REQUEST

Current Zoning: B-2(CD) (general business, conditional)
Proposed Zoning: B-2(CD) SPA (general business, conditional, site plan amendment)

Approximately 1.263 acres located on the north and south side of Northlake Creek Drive, west side of Reames Road, and south side of West W.T. Harris Boulevard.

The petition proposes to amend an existing approved rezoning site plan to allow for the development of EDEE and commercial uses with accessory drive-through lanes on an out parcel within an existing shopping center.

SHEET NUMBER:
RZ-2

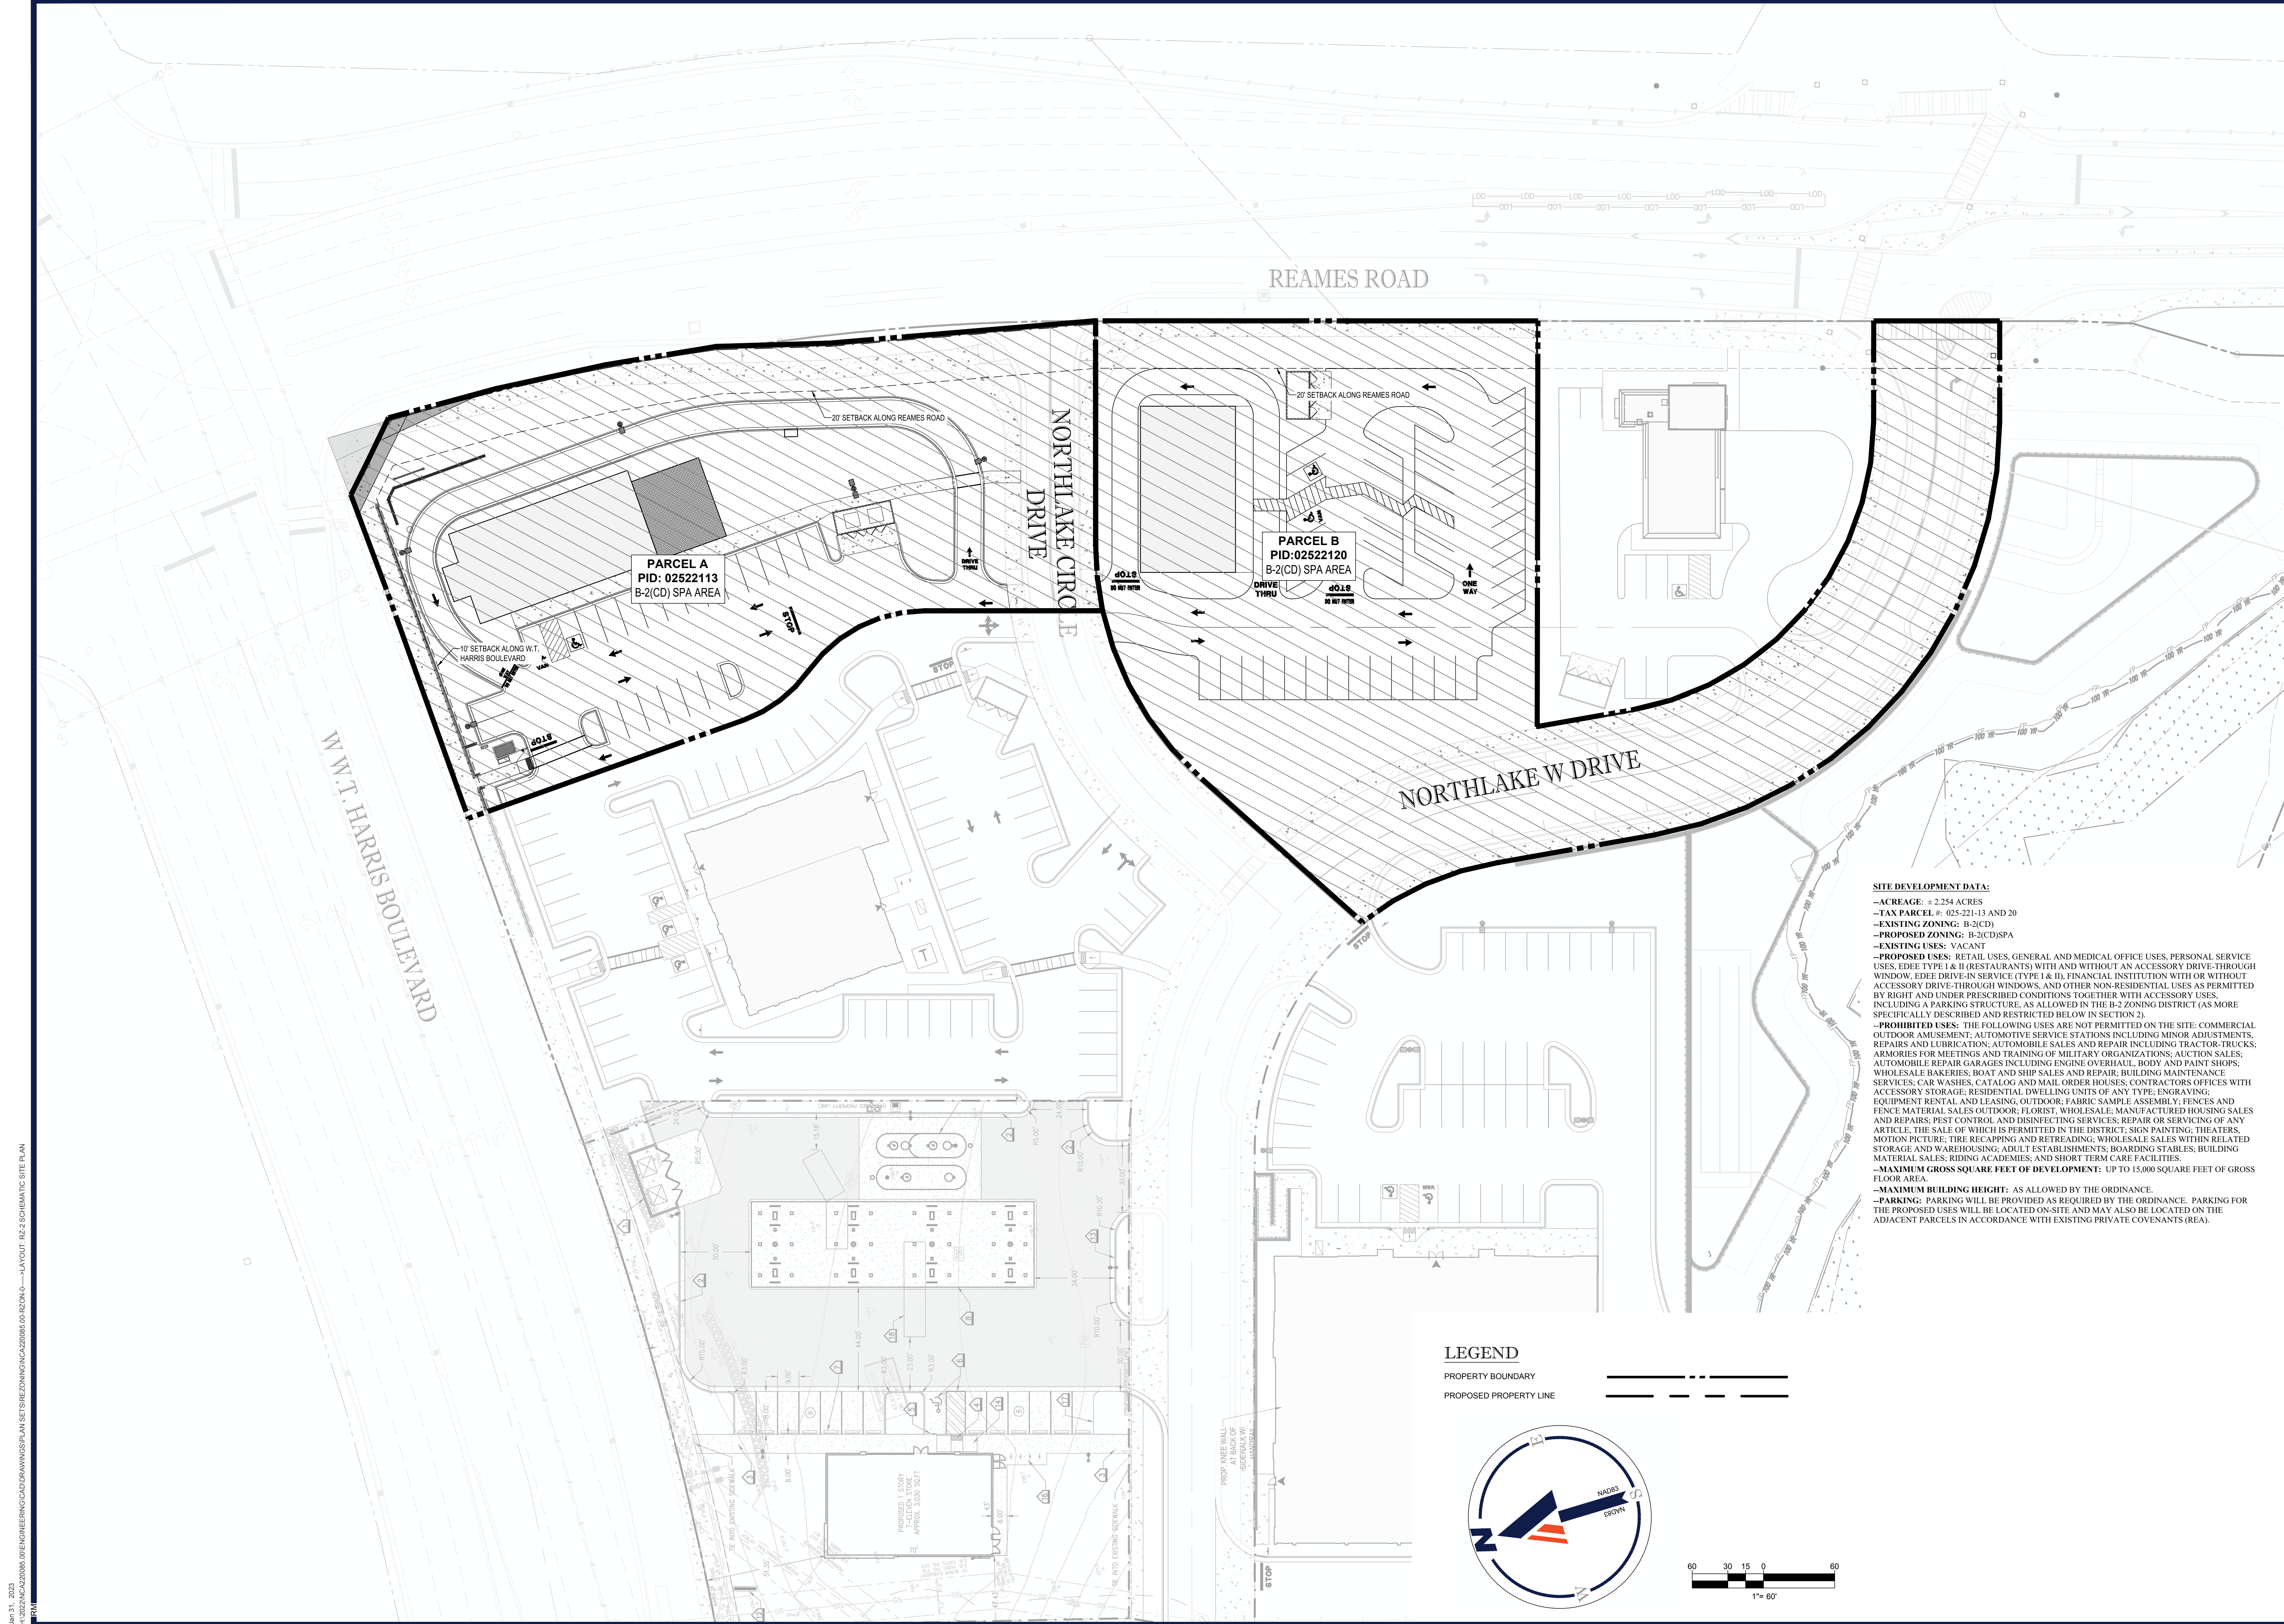
- ~~1. W T Harris Blvd: Location of future back of curb and gutter to be 44 feet from roadway centerline to accommodate the Charlotte Streets Map with a roadway typical section of 6+ Boulevard, Shared Use Path. **Addressed**~~
- ~~2. Reames Road: Location of future back of curb and gutter to be moved to 38 feet from roadway centerline to accommodate the Charlotte Streets Map with a roadway typical section of 4+ Avenue, Buffered/Separated Bike Lanes. **Addressed**~~

- ~~3. The proposed site plan shows two principal structures on the site, while the conditional notes refer up to four proposed principal structures. The proposed number of structures shown on the site plan and noted in the conditions must match. **Addressed**~~
- ~~4. Staff recommends that the site plan be revised to incorporate design elements that would increase the consistency of site with the design requirements of the Regional Activity Center Place Type such as relocating the drive through lanes so that they are not located between the buildings and the street. **Addressed**~~
